THE HILLS SHIRE COUNCIL

15 March 2018

Council received notification on 5 February 2018 of a Section 75W application made to the NSW Department of Planning and Environment to modify a Part 3A approval for a seniors living development at 34-36 Memorial Avenue, Kellyville.

DA403
B

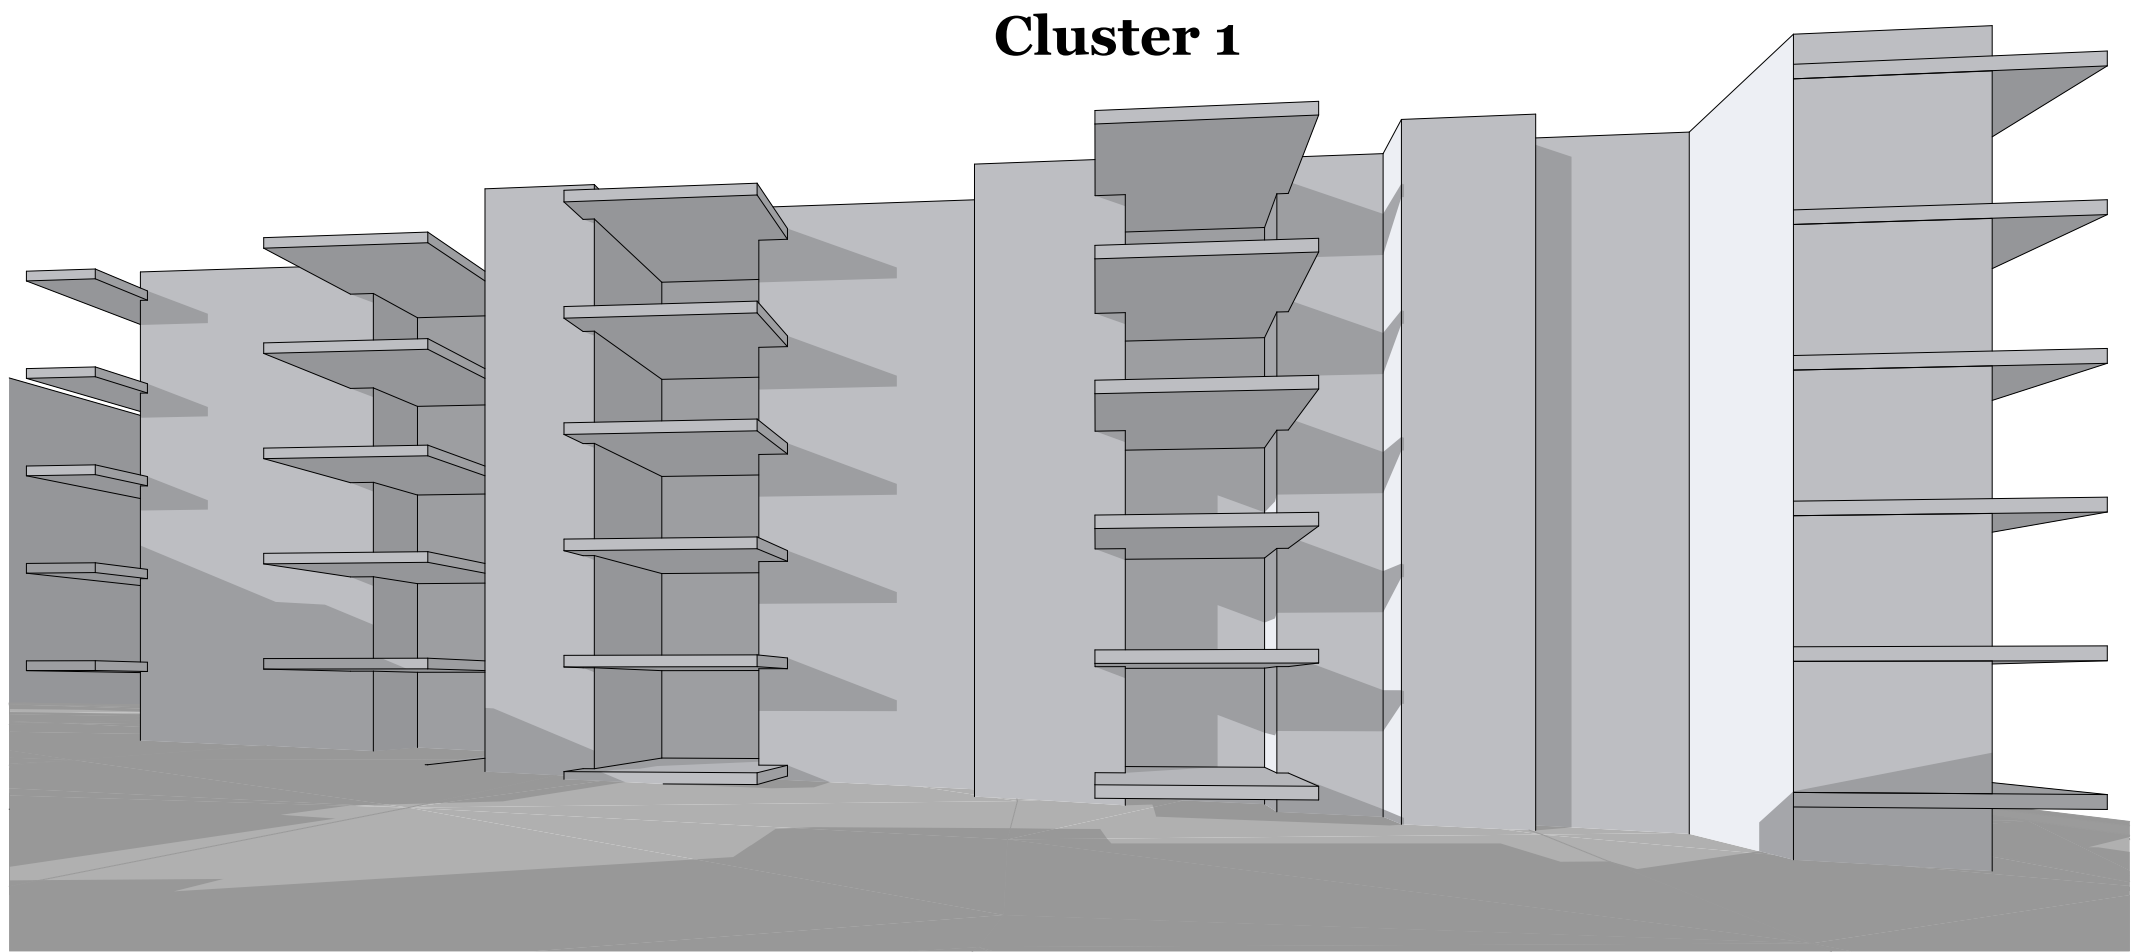
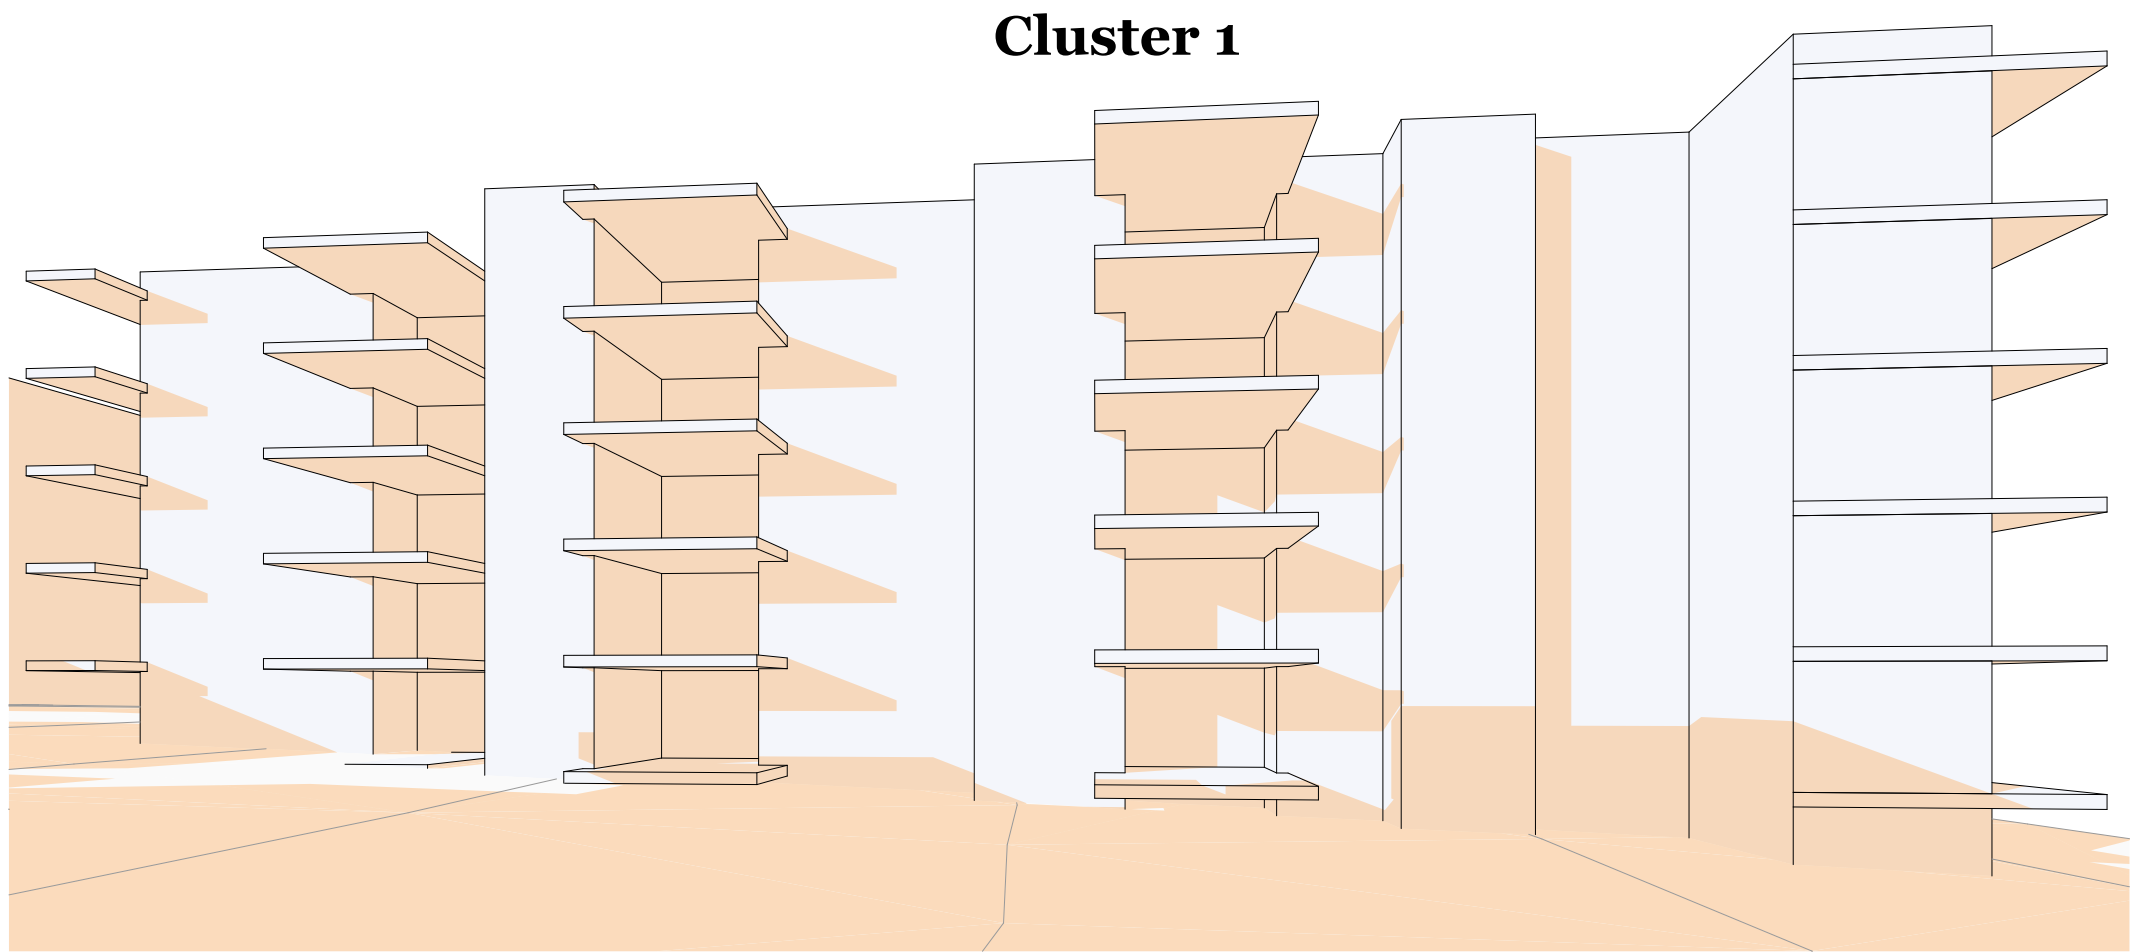
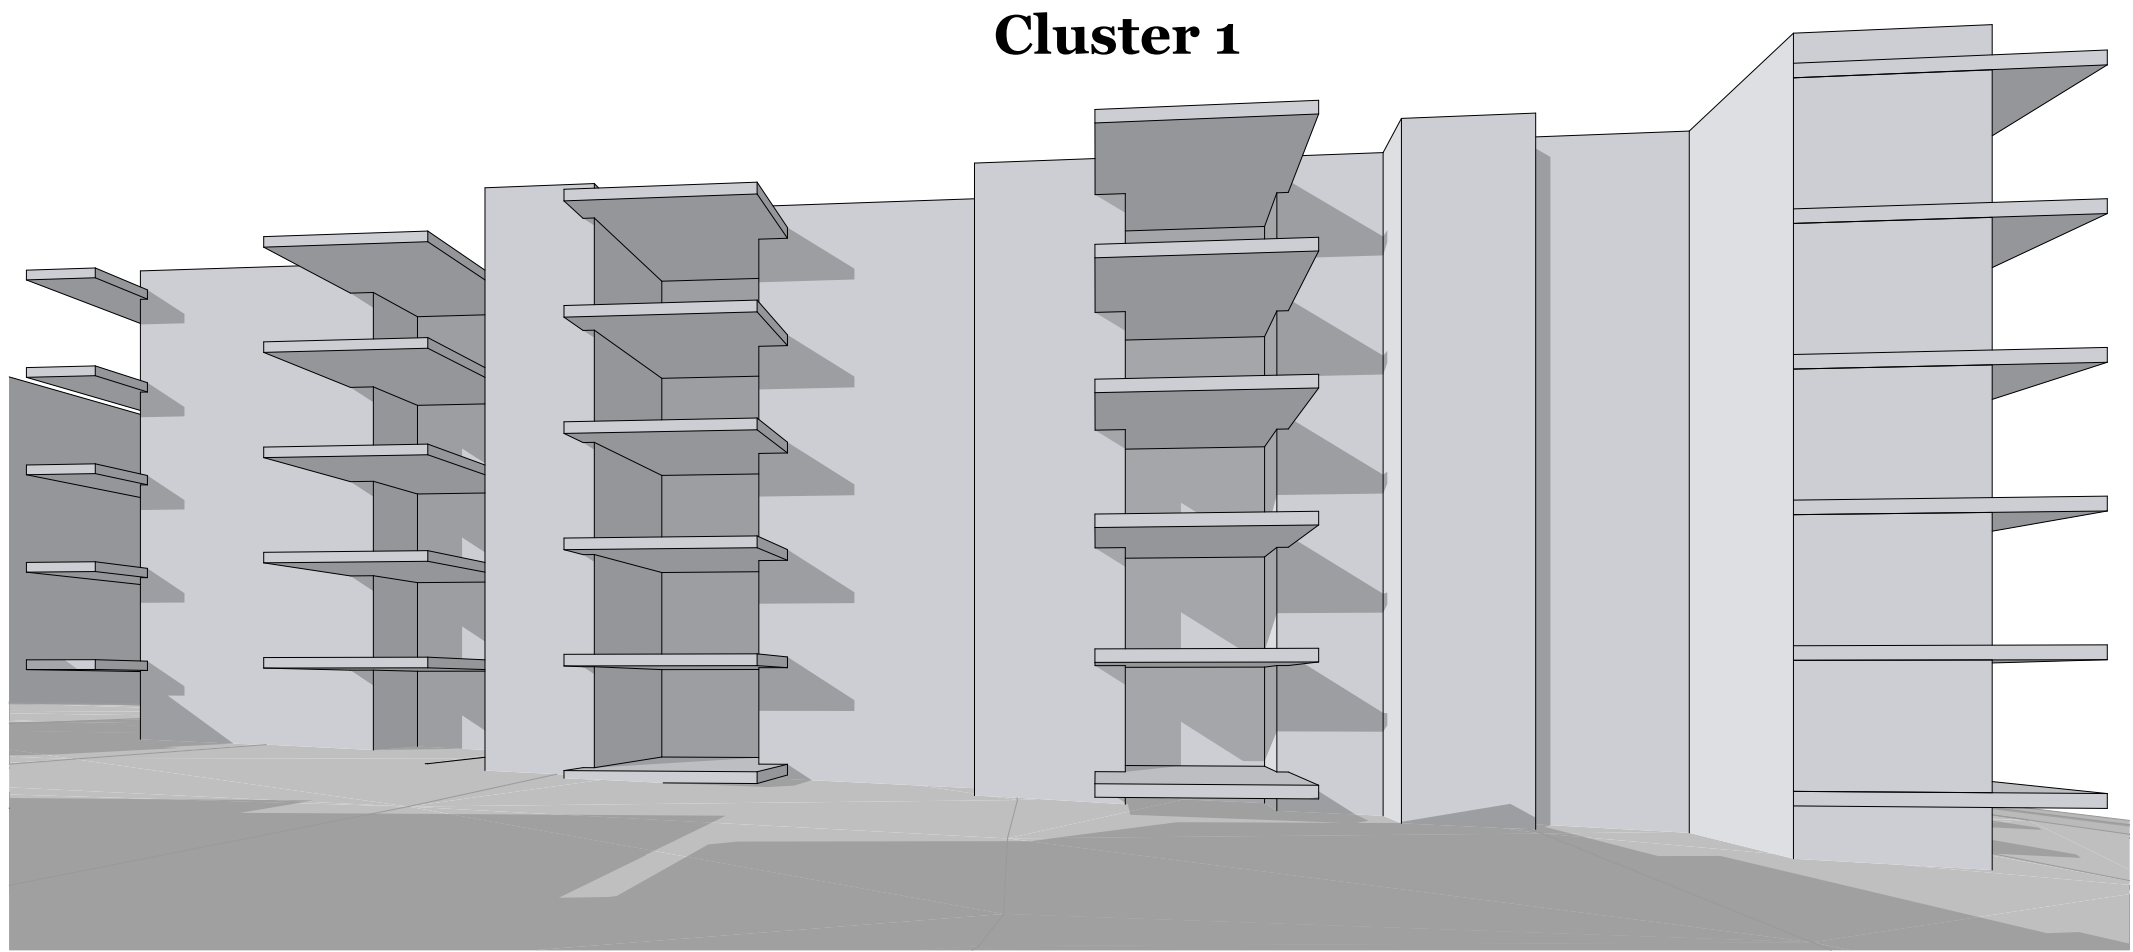
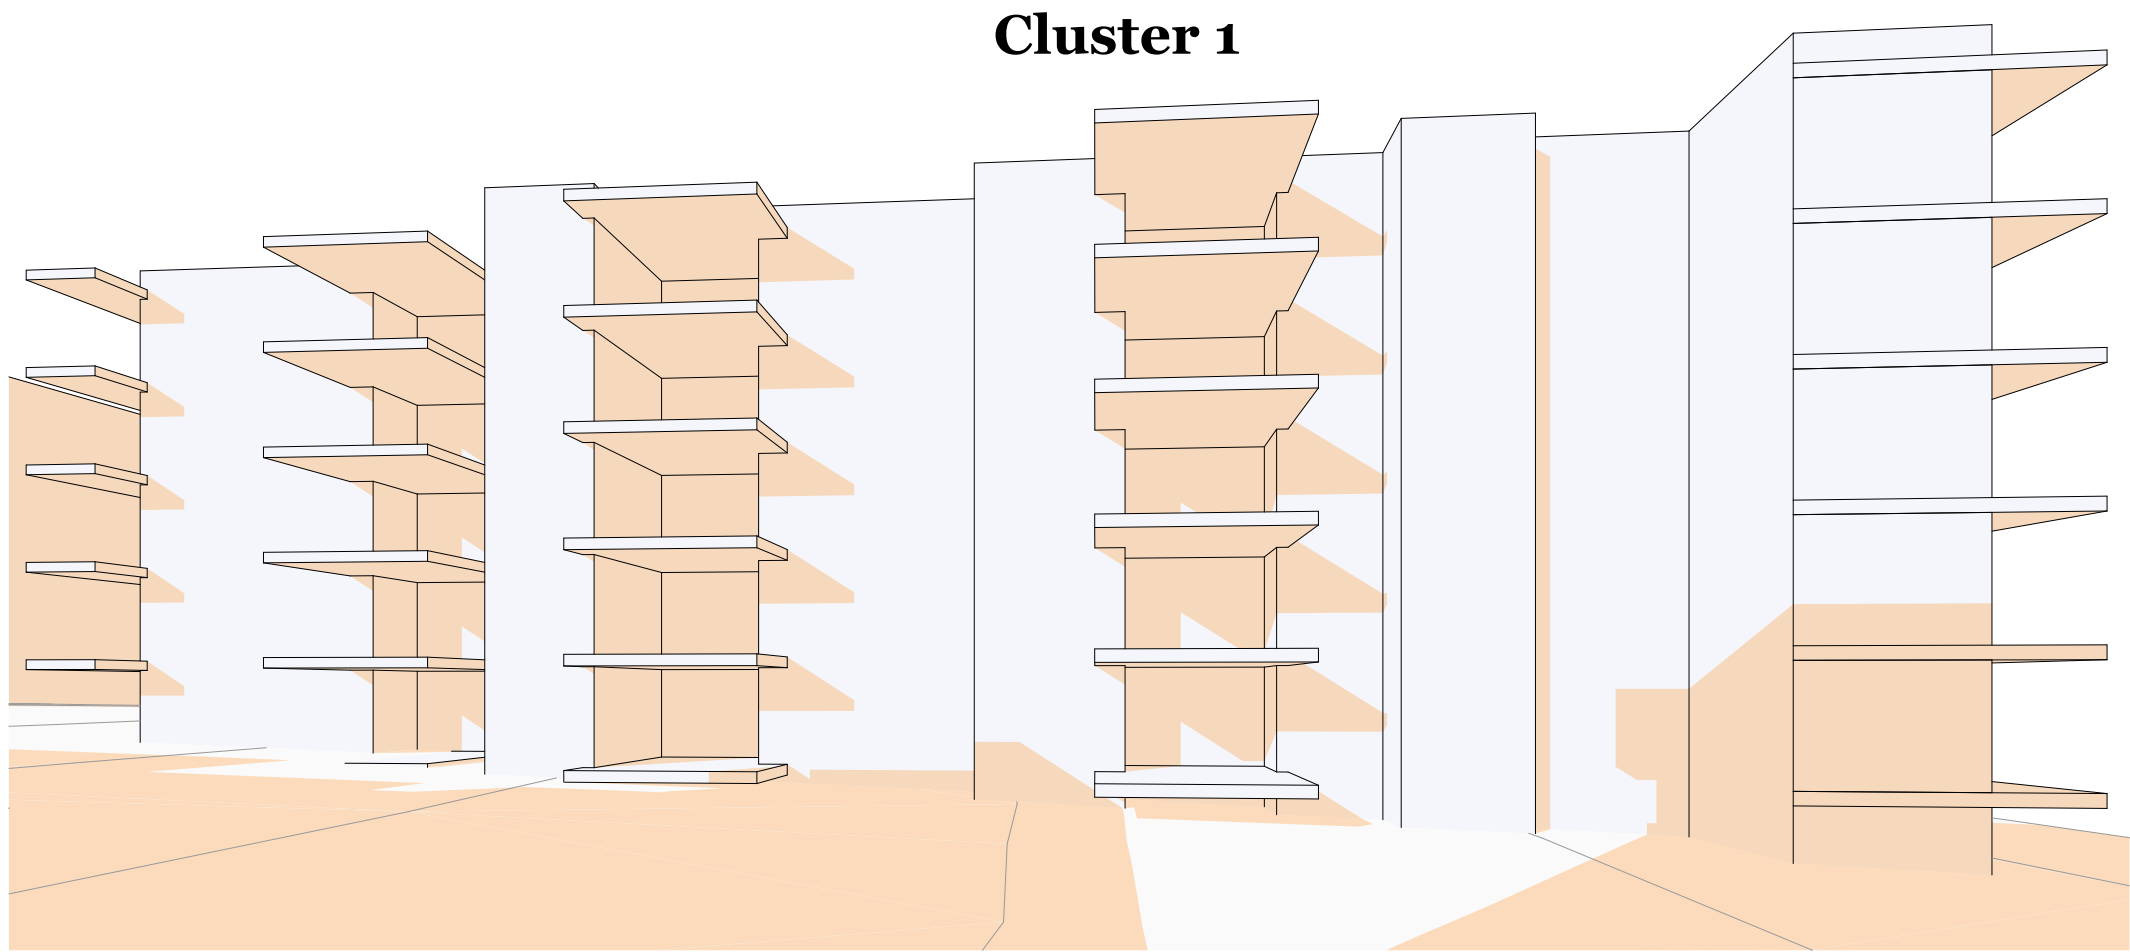
- The proposal has not provided a clear assessment of the proposals impact on the solar access afforded to adjoining buildings known as Cluster 5, or the RACF impact on the solar access afforded to the proposed buildings. Analysis similar to that provided for Cluster 1 should be provided to the northern elevation of Cluster 2, 3 and 4 (to assess the impact of the RACF), and the northern elevation of Cluster 5.
